Cc: Michael Eastham
Subject: Saltbox- Drainage

Thank you for your time this morning. As promised, below is a summary of the outstanding drainage issues/ my comments.

9. The DOC application (BE/2/19/DOC) should be submitted in full accordance with the advice within the drainage submissions checklist (attached for ease of reference). If pre-commencement conditions are to be avoided on the other application (BE/135/18/PL) the detailed submitted will need to be to level set out within the drainage checklist.

Drawing Title: PHASE 1 DRAINAGE STRATEGY PLANNING SHET 2 OF 3

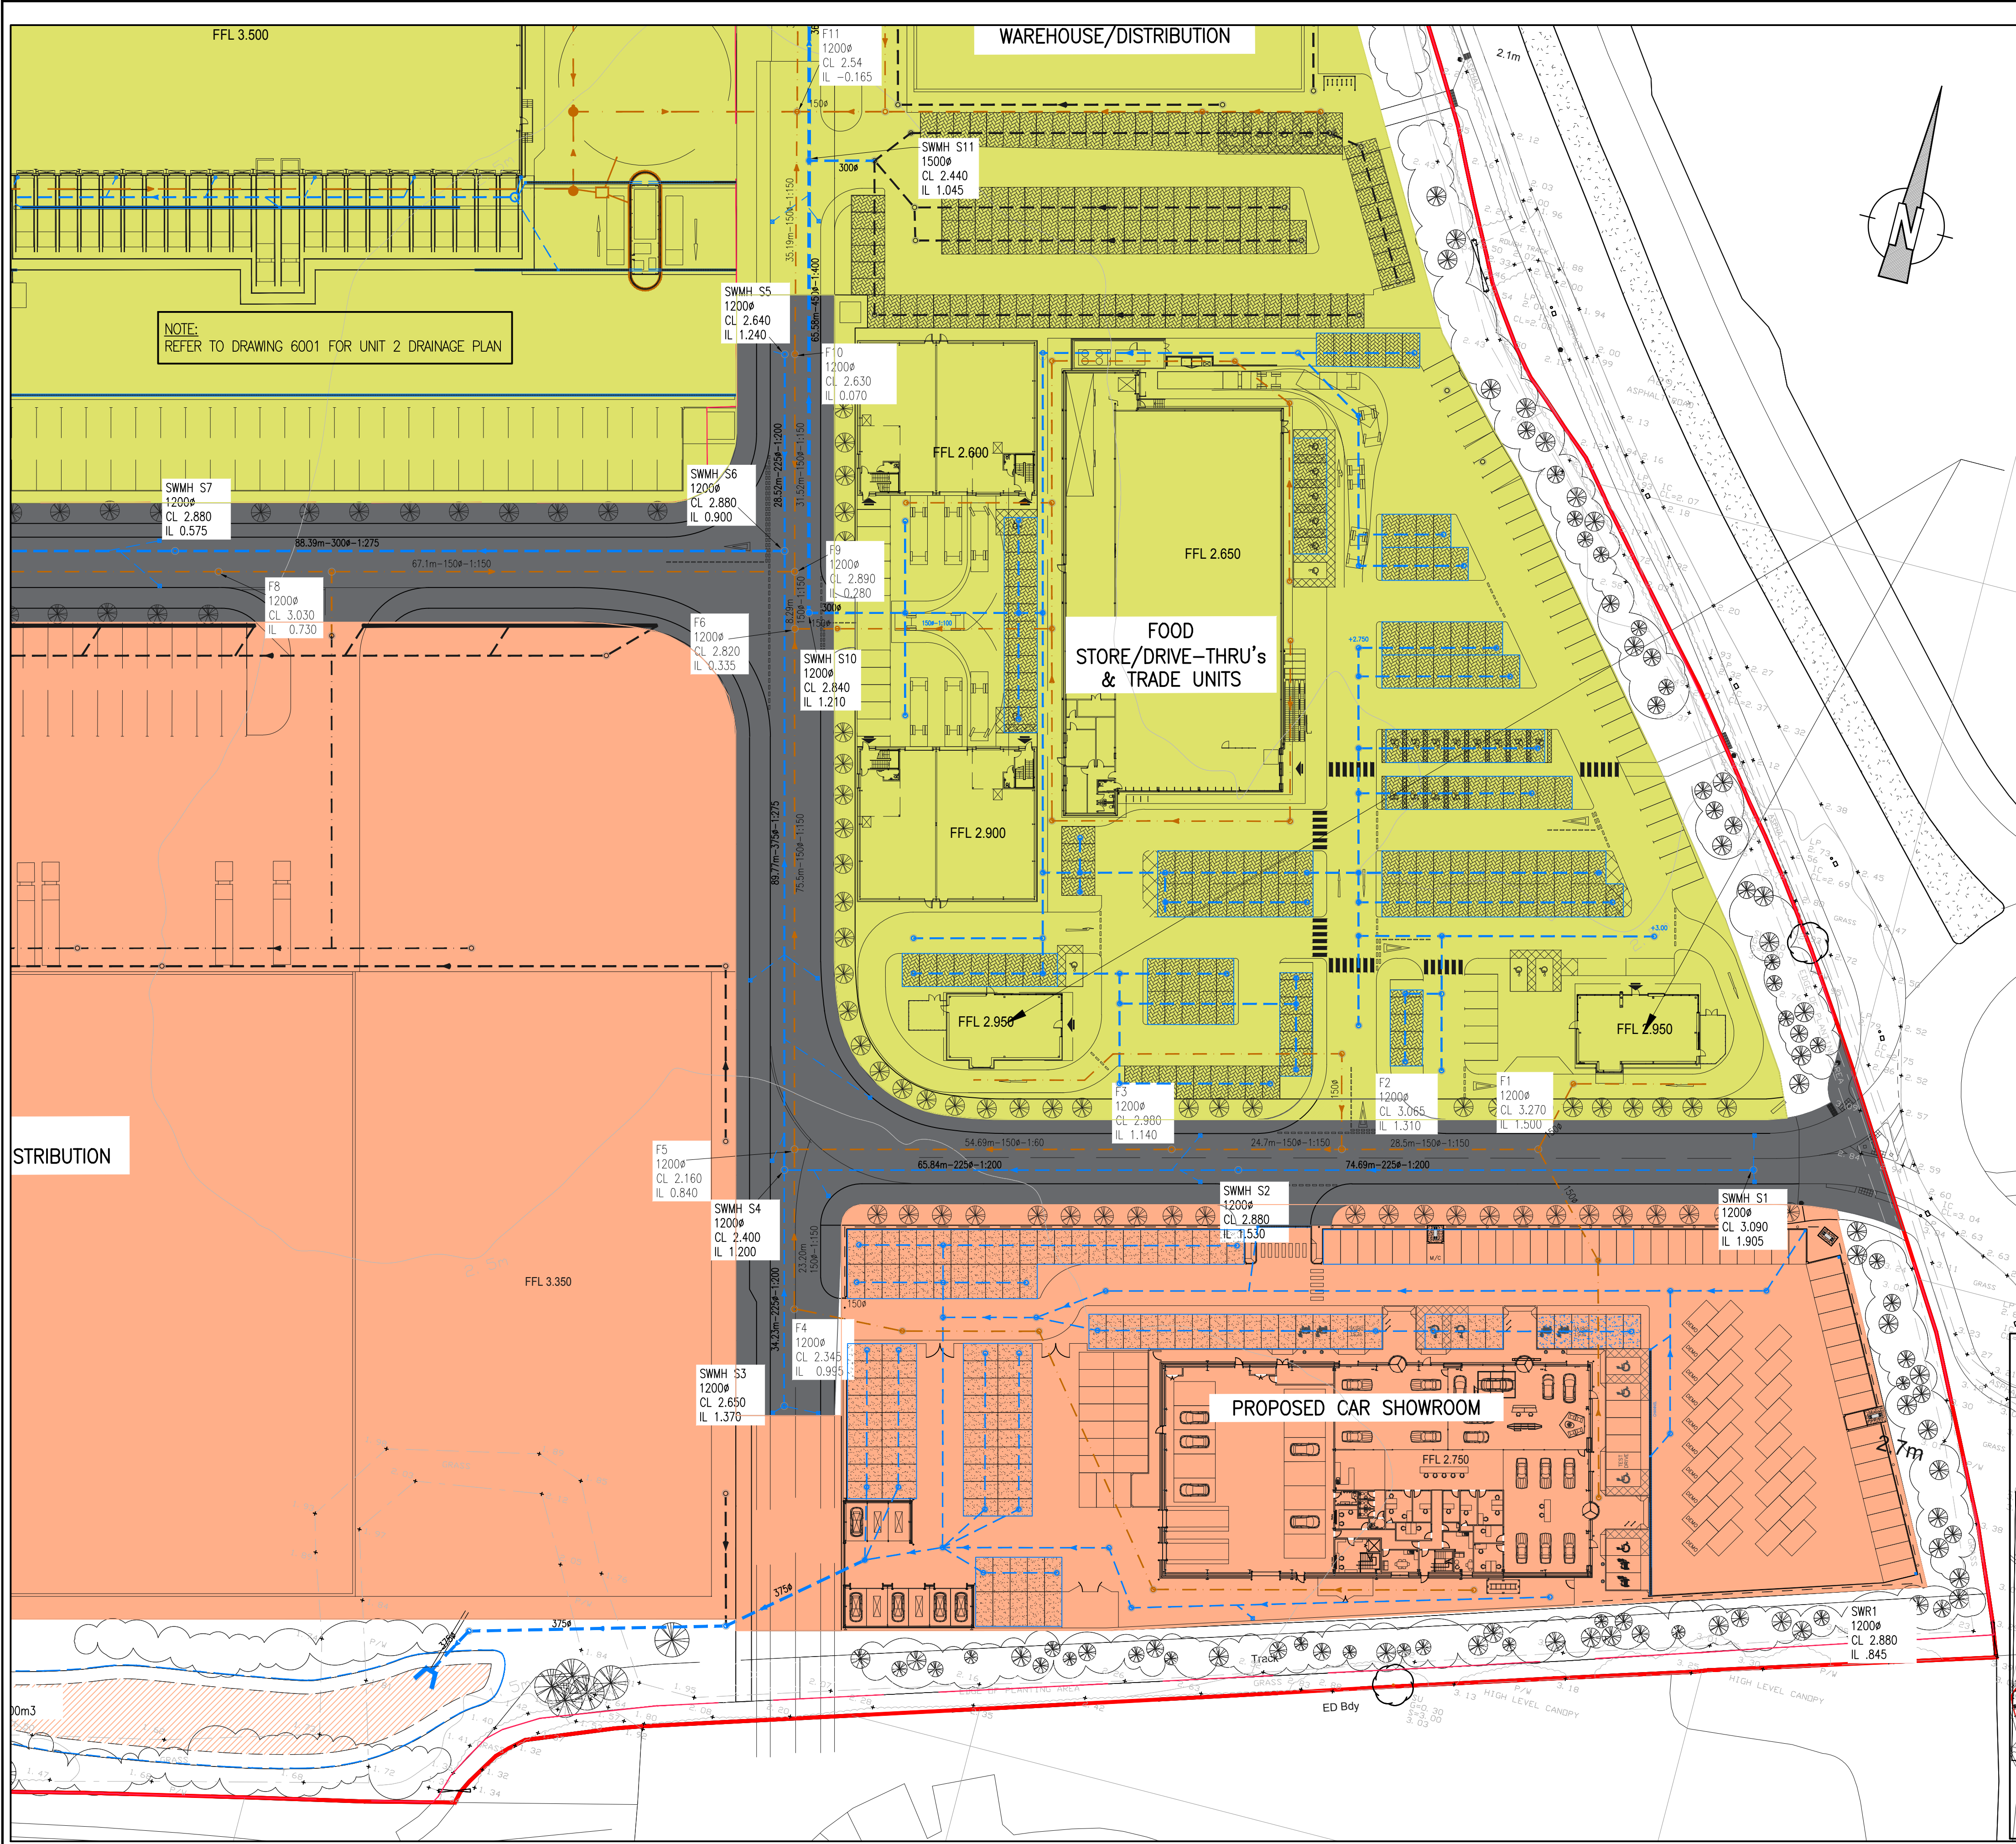
4. Confirmation will need to be provided that 8m easement is provided to the top of bank of main river, and 3m to the top of bank of ordinary watercourse.

5. I will need confirmation that the proposed outfall to the north is constructible given its proximity to overhead cables. If this cannot be guaranteed the outfall should be repositioned away from the overhead cables.

6. The attenuation basins are proposed to be deeper than groundwater. Therefore the basins will need to be lined. Flotation calculations must be submitted with the DOC application to demonstrate that the design adequately accounts for these forces. If this results in changes to basin footprints revised plans will need to be submitted for BE/135/18/PL.
